MORGAN AND MORECAMBE OFFSHORE WIND FARMS: TRANSMISSION ASSETS

Response to Section 51 advice

December 2024

Document reference: S_S51_1

Drawing Number:
BP-GBR-MORG-REG-0184

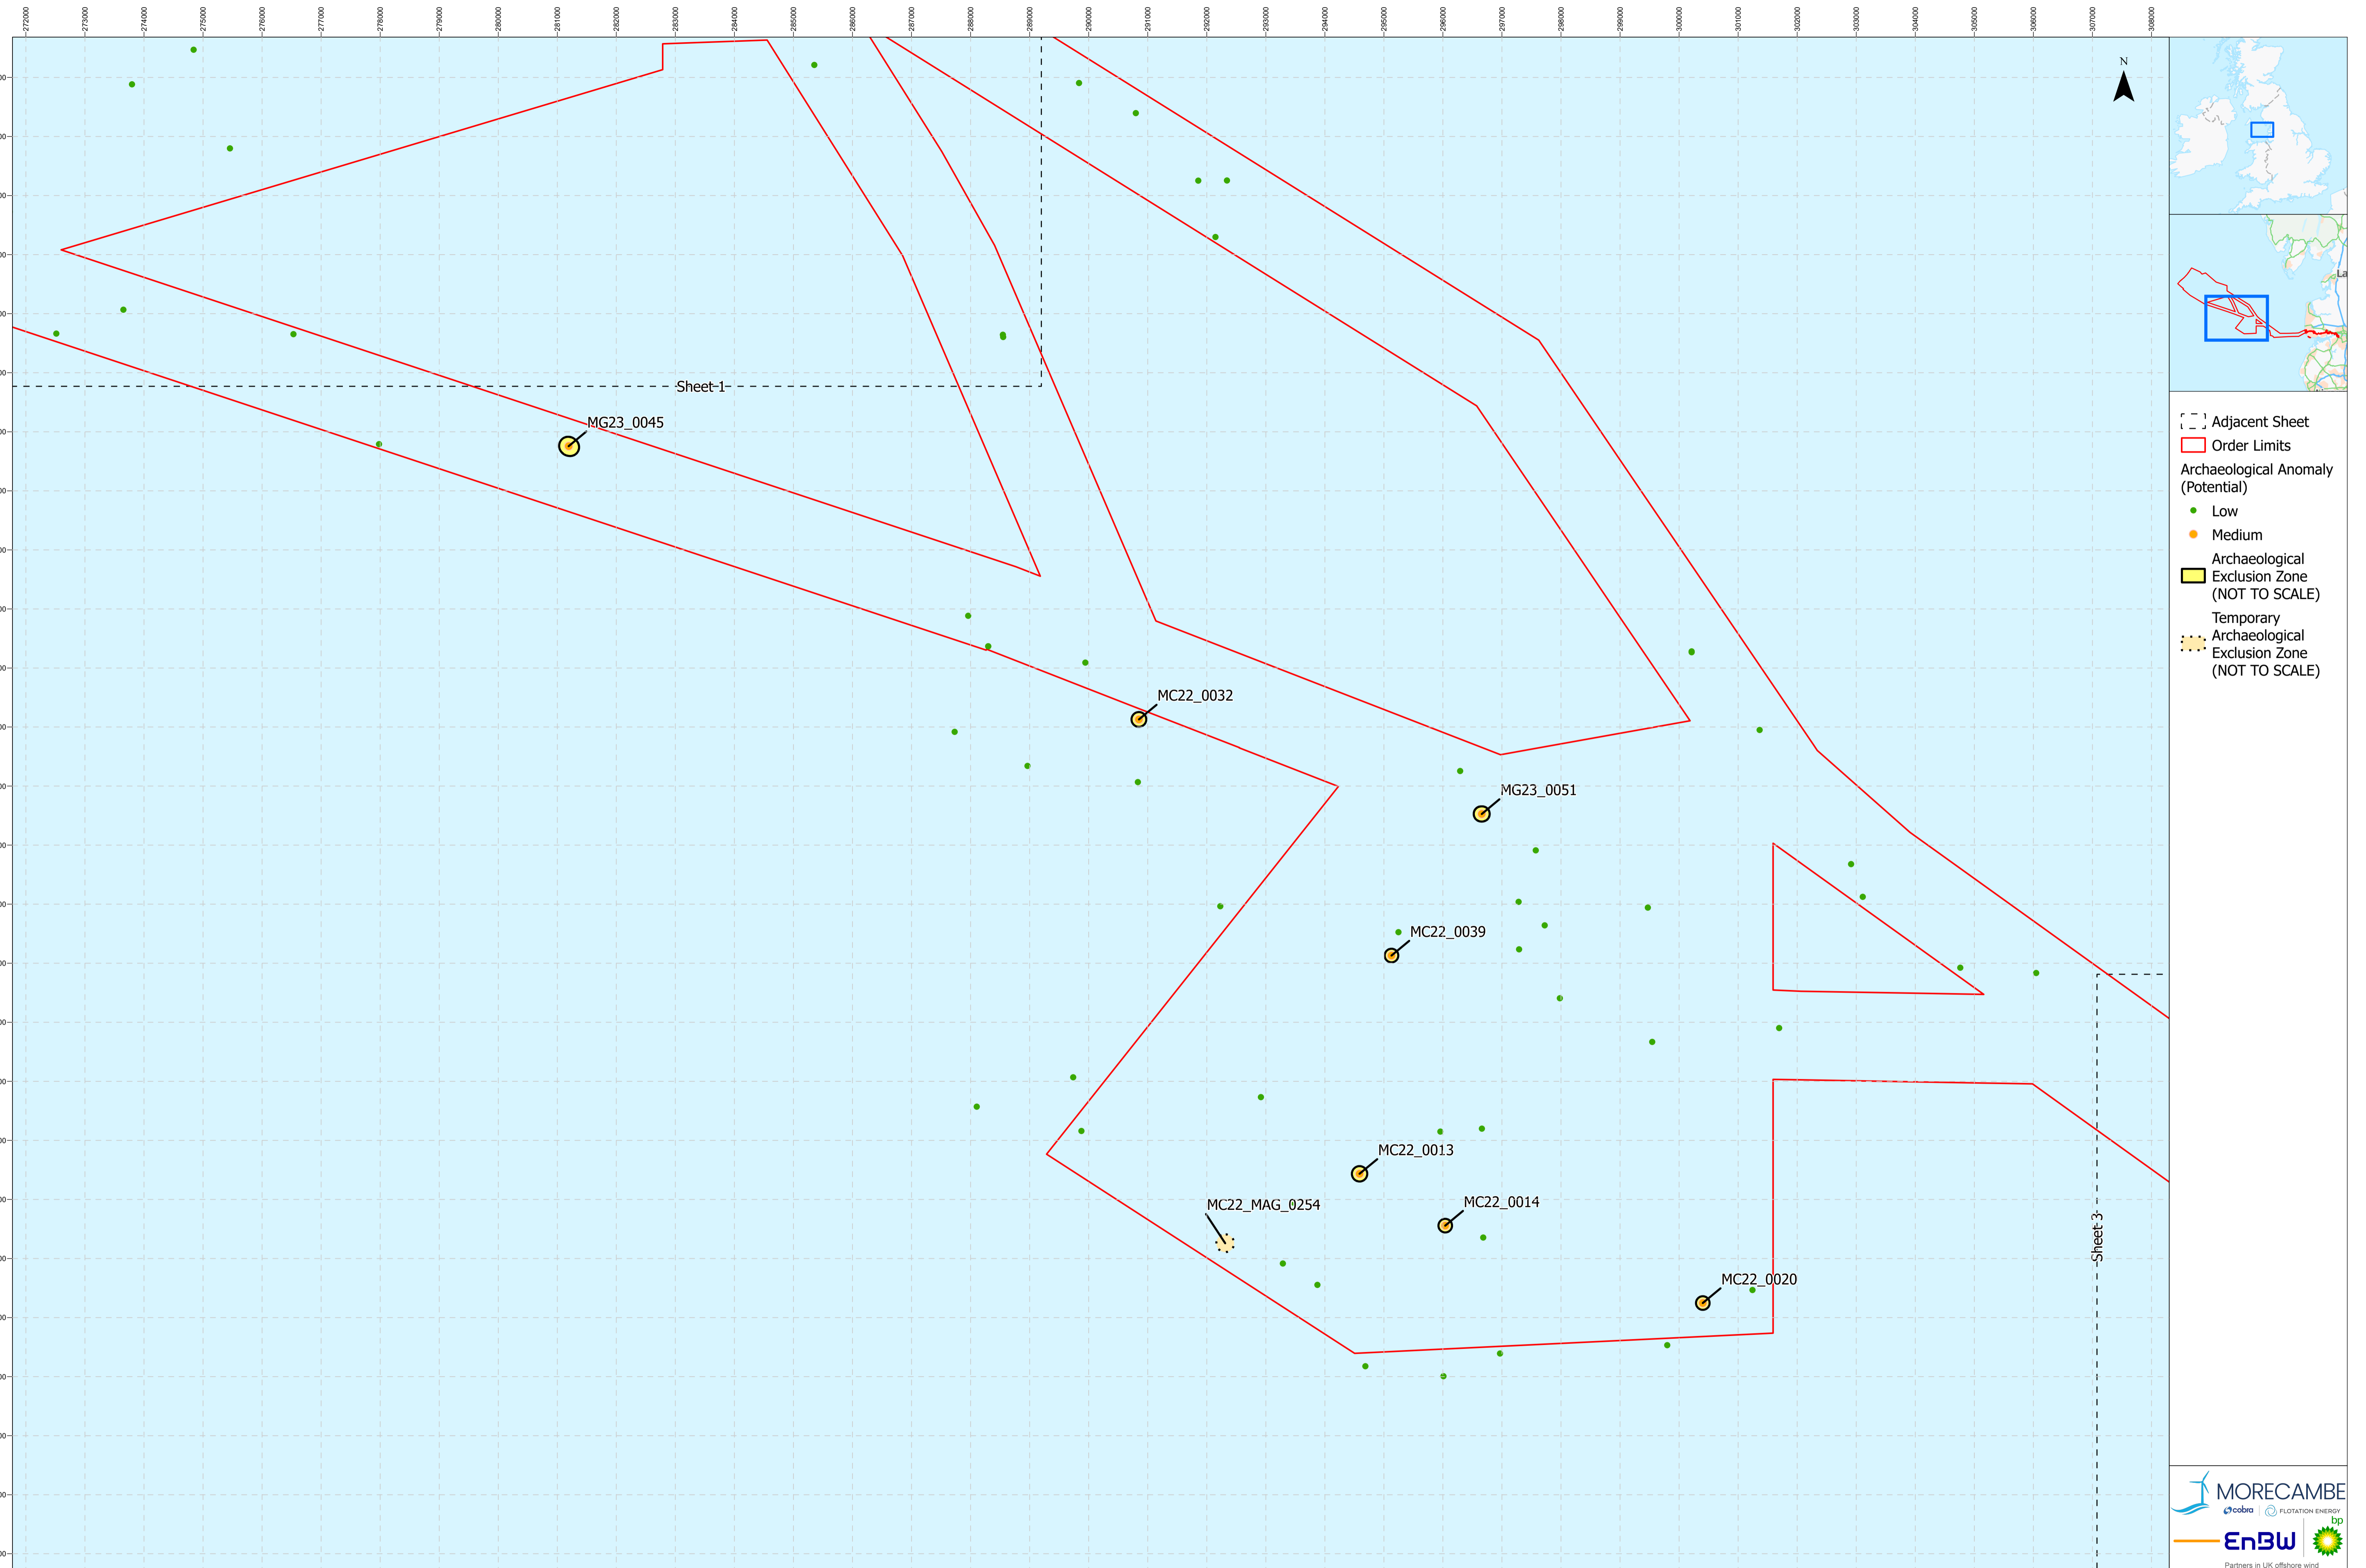
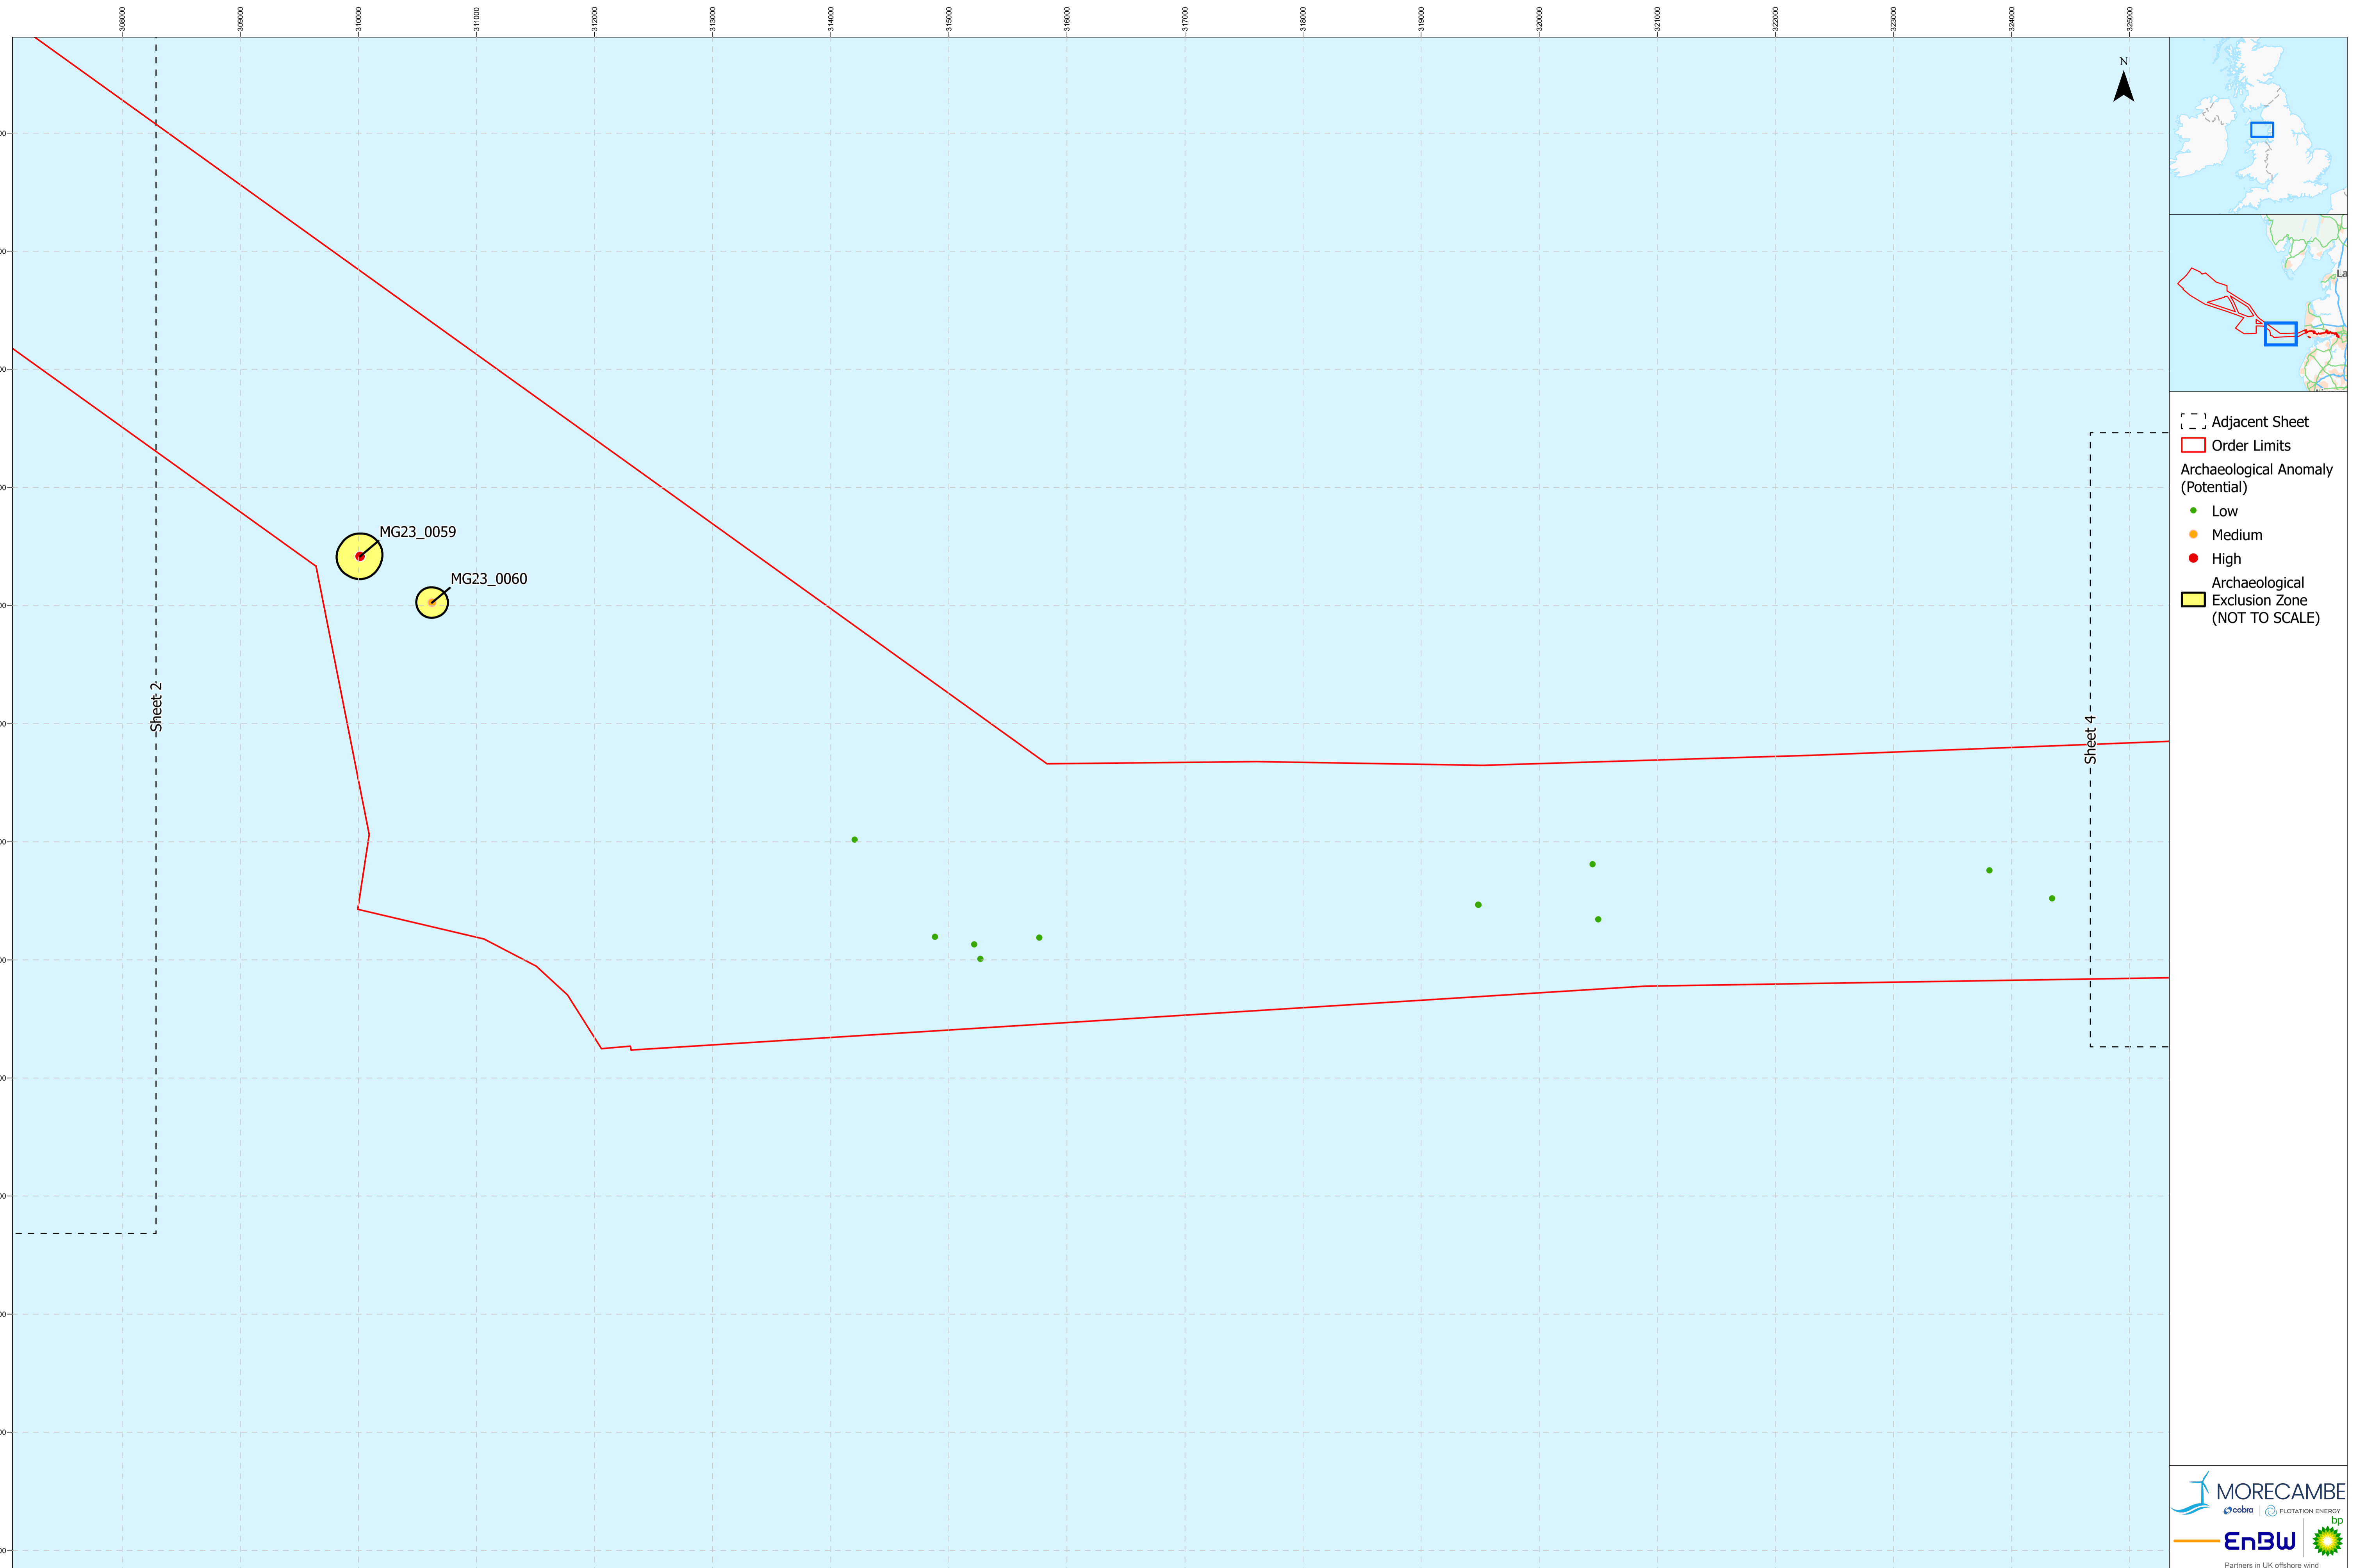
Topic	Section 51 advice	Applicants' response
		reference: B16/F02) to the Planning Inspectorate. The document also contains a Schedule of Changes.
Statutory and Non-Statutory Features of (The Offshore) Historic Environment Plan	<p>“Standalone figure B17 (Statutory and Non-Statutory Features of (The Offshore) Historic Environment Plan) only shows offshore exclusion areas rather than specific features, however the specific sites are shown on the ES figures. The Applicants are advised to provide an updated set of figures with appropriate labelling of the features being represented.”</p>	<p>The Applicants have reviewed the Offshore Historic Environment Plan alongside the ES Volume 2, Figure 8.5 and can confirm that the location of the geophysical anomalies shown as high medium and low are the same.</p> <p>The Applicants have reviewed the Offshore Historic Environment Plan alongside the ES Volume 2, Figure 8.6 and can confirm that Archaeology Exclusion Zone (AEZs) and Temporary Archaeology Exclusion Zones (TAEZs) are the same. To enable cross-referencing between the documents, named wrecks have been added to their corresponding ID reference. The Applicants have submitted the updated Offshore Historic Environment Plan (document reference: B17/F02) to the Planning Inspectorate. The document also contains a Schedule of Changes.</p>
